From: Mandy Colwell [REDACTED]
Sent: 11 October 2015 15:51
To: Simon Davis
Cc: Planning
Subject: P/86/15/PL

We see that Mr Blumer has made statements in response to various comments raised by parties in regard to Planning Application No. P/86/15/PL.

PROJECT	11 Abbotsbury Road	DATE	23 June 2015
TITLE	Proposed Plans and Elevations	DRG NO	IBA/433/02
SCALE	1 : 100	REVISIONS	A

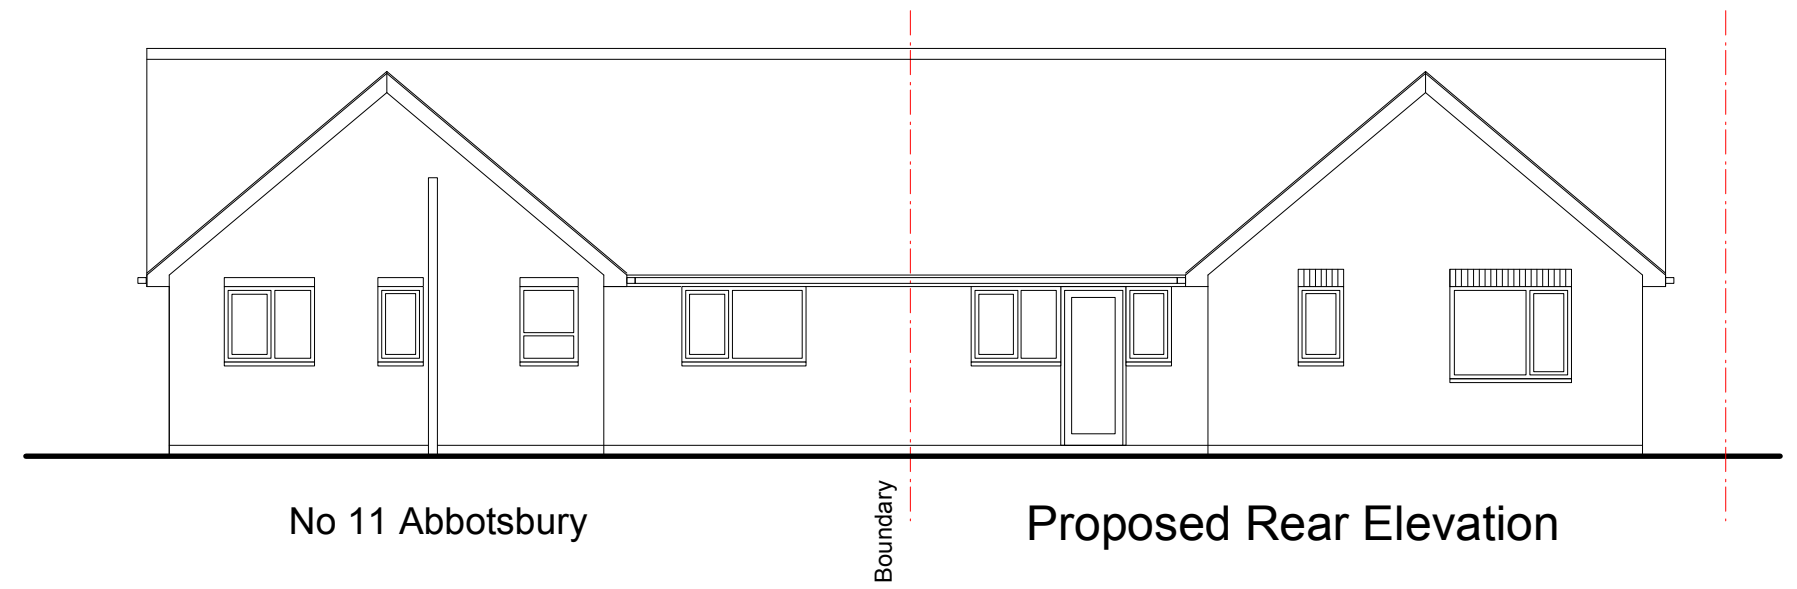
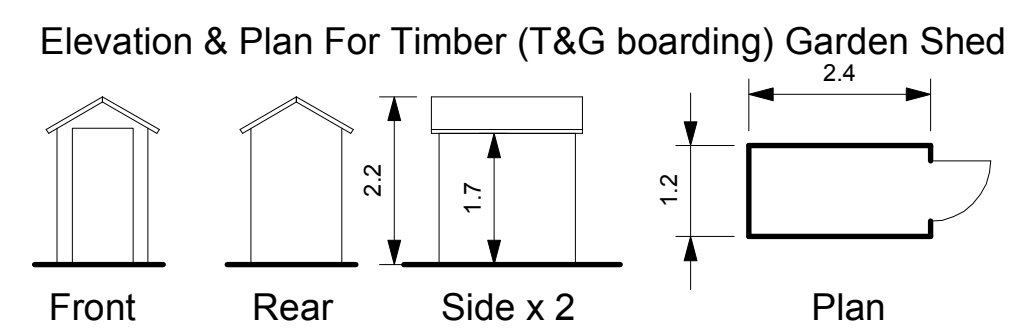
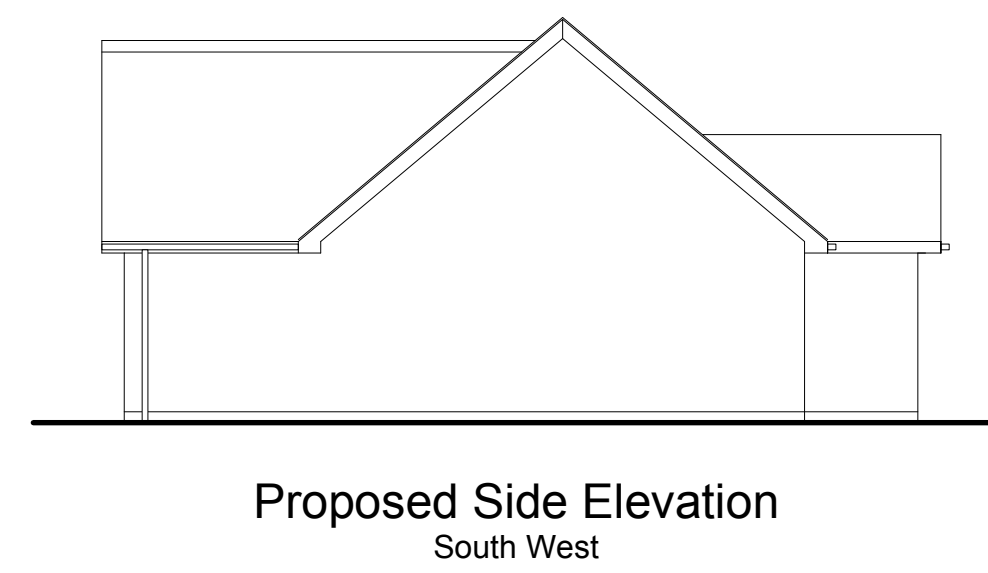
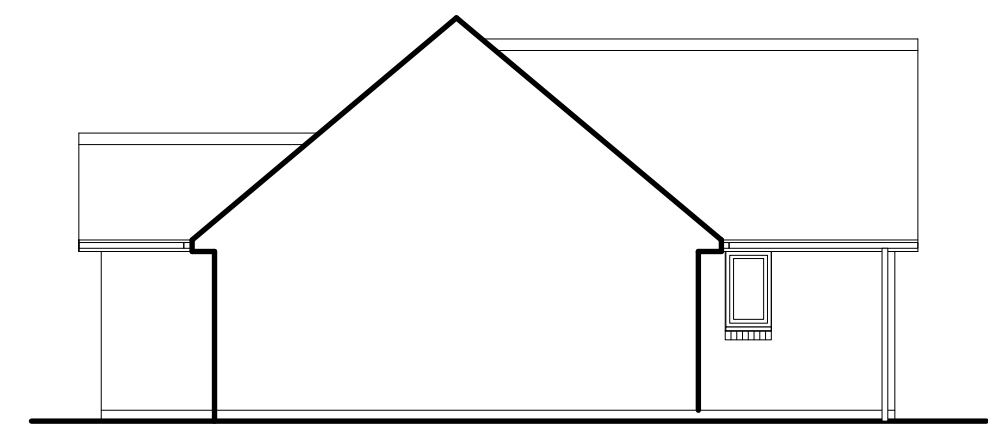
Unless the writer has personally visited our home and garden he would have no idea how much negative impact this will have on us. It may be of single story design, but the roofline would be of pent construction. It would be in our view and it would block light.

It *will* take away light from our rear primary living quarters.

It *will* take away light from our garden.

It *will* be claustrophobic.

It *will* spoil our view.

It *will* present an unneighbourly form of development
